**INFRASTRUCTURE PLANNING**  
**THE INFRASTRUCTURE PLANNING (EXAMINATIONS PROCEDURE) RULES 2010**  
**THE THANET EXTENSION OFFSHORE WIND FARM ORDER**

**Comments on Responses to ExQ1**  
**Submitted on behalf of the Port of London Authority and Estuary Services Limited**  
(Rule 8 letter 18 December 2018)

Unique Reference Number	EN010084
Rule No.	8
Document Ref.	PLA 9 / ESL 9
Author	Winckworth Sherwood LLP
Date	5 February 2019

Radar Line of Sight Coverage Plan

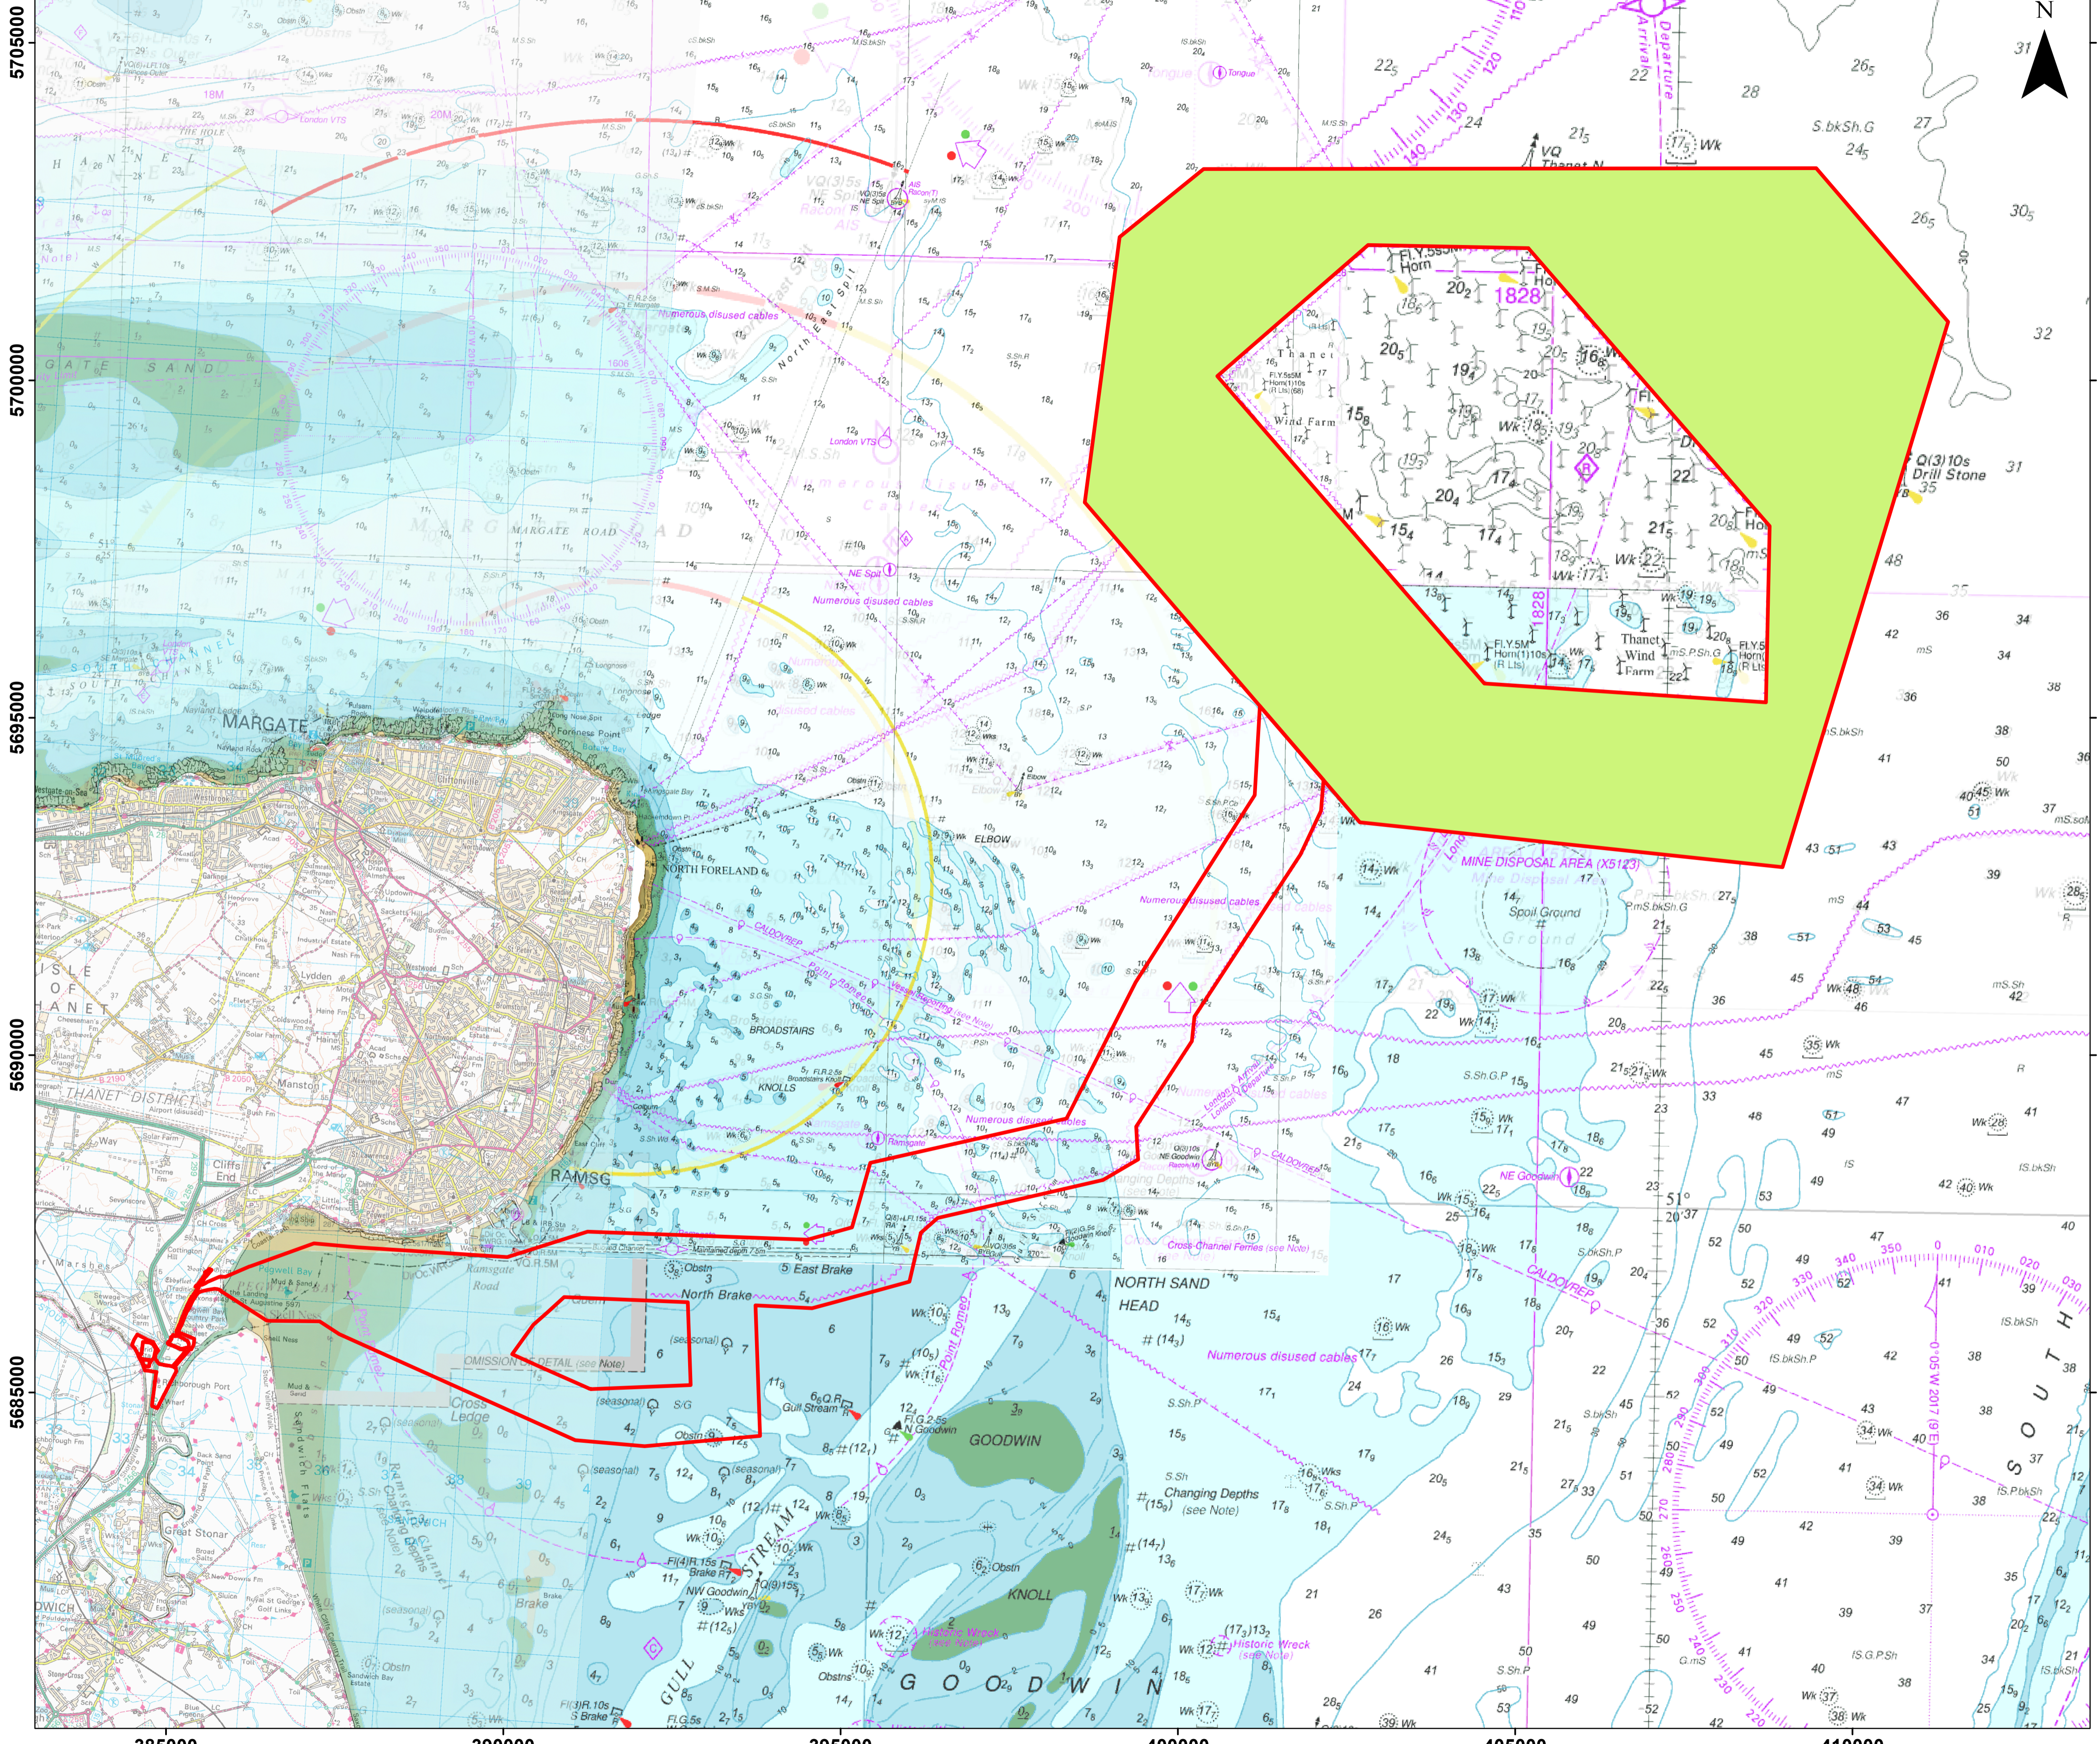
Question	Response summary/extract	PLA/ESL comments
1.12.28	Comments regarding radar impact.	ESL made extensive comments in its Deadline 1 submissions on the adverse impact that wind farms have on radar and the likely impacts of the proposed extension.
1.12.29	“Next steps: inc agreement to share draft NRA prior to submission (done in Mar/Apr)”	Neither the PLA nor ESL received the draft NRA to comment on prior to the application being submitted.
1.12.31	Explanation on the moveable exclusion zone.	ESL would assume that safety zones would be enforced by a guard vessel. In practice, it is likely that the 500m exclusion would be greater due to the safety zones being enforced by a guard vessel presence, which itself would not be able to enter the 500m zone. That would in turn push traffic further away from the exclusion zone and further constrict the channel.

Figure 3: PLA Simulator extent (ESL Pilot Launch tracks also shown - demonstrating area of activity for North East Spit Station).

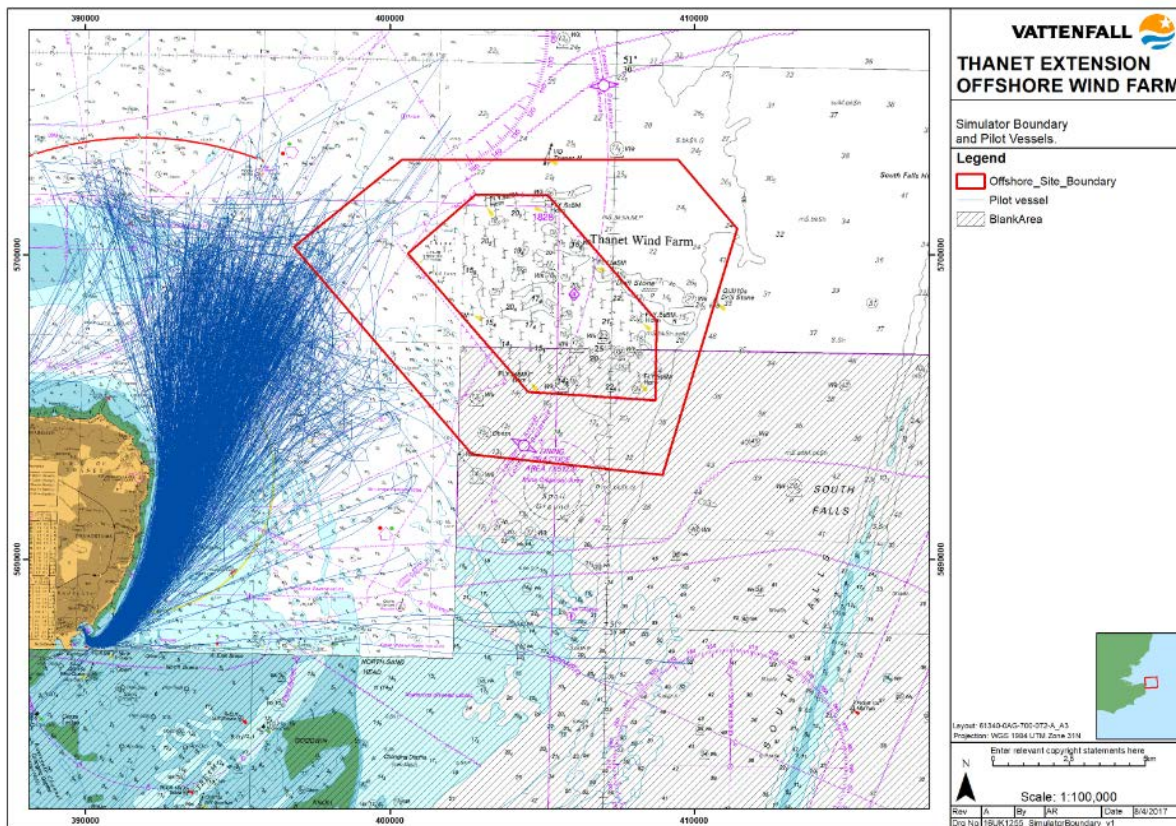
Question	Response summary/extract	PLA/ESL comments
Annex N)	<p>“The simulation study is a qualitative tool in order to support the wider assessment of the overall NRA and followed a methodology which had been accepted and supported by stakeholders during consultation.</p> <p>The study was undertaken with the backing and support of the Port of London Authority, with agreement to utilise their pilot training simulator and senior marine pilots who were involved in the planning and execution of the simulation.”</p>	<p>proposed extension of the wind farm.</p> <p>The PLA and ESL agree that the meetings set out at paragraph 9 of Annex N took place. However, the presence of PLA and ESL representatives at these meetings and on the days of the Simulations themselves cannot be taken to suggest agreement in the conclusions drawn from the Simulations, particularly in the light of the issues that the pilots/coxswains expressed at the time of the study.</p> <p>The PLA and ESL did not disagree with the scope and methodology set out at the meeting in August 2017 on the basis of what the simulations were intended to demonstrate. This is because the Applicant’s consultants had explained that traffic capacity in the area and collision risk were to be assessed separately.</p> <p>The simulation study was only able to demonstrate that looking at a range of vessels in isolation, with average conditions, that for the most part there would be enough sea-room to continue to conduct boarding and landing in this area. However, it must be noted that even without the full range of vessel size, type and metocean and traffic</p>

Question	Response summary/extract	PLA/ESL comments
		<p>conditions, 1 in 14 runs was still marginal.</p> <p>The PLA and ESL do not agree with how the results of the survey have then been used by Marico to inform the NRA. They have placed too much weight on the outcome of these simulations and have not considered the limitations of the study. In order to use the simulations to assess collision risk a much more extensive study would be required.</p>
	<p>“the draft pilotage simulation report was issued to ESL and the Port of London Authority who confirmed receipt and onward circulation although no comments on the report were provided to imply disagreement – despite request.”</p>	<p>The PLA and ESL agree that they were sent a copy of the draft simulation report. However, this was just a record of the runs that took place on that day and neither PLA nor ESL is aware that comments were requested.</p>

<p>1.12.3 (b) (answered in Annex N)</p>	<p>“It was noted that ESL explained (in the meeting of 14-Aug-2017) usage of a planning diamond tool (enabling information on appropriate ship directions based on metocean conditions). In the absence of receiving this the metocean conditions were informed by consultation meetings, data analysis and agreed by participants on the set-up day.”</p>	<p>ESL do not recall agreeing to provide any planning tools. They do not have set tools for making lees or boarding area decisions.</p>
<p>1.12.3 (d)</p>	<p>“Usage of a tug mode (as the Pilot Launch was required due</p>	<p>ESL consider that speed is not the only difference</p>

Question	Response summary/extract	PLA/ESL comments
(answered in Annex N)	to the PLA Simulator not possessing a pilot launch model). The fundamental limitations of this mode related to transit speed”	between a tug and pilot launch. The visibility from a tug is different as well as differing handling. Tugs drive differently, have a different rate of acceleration and differ in responsiveness. The ship to ‘launch’ interaction is also likely to be different.
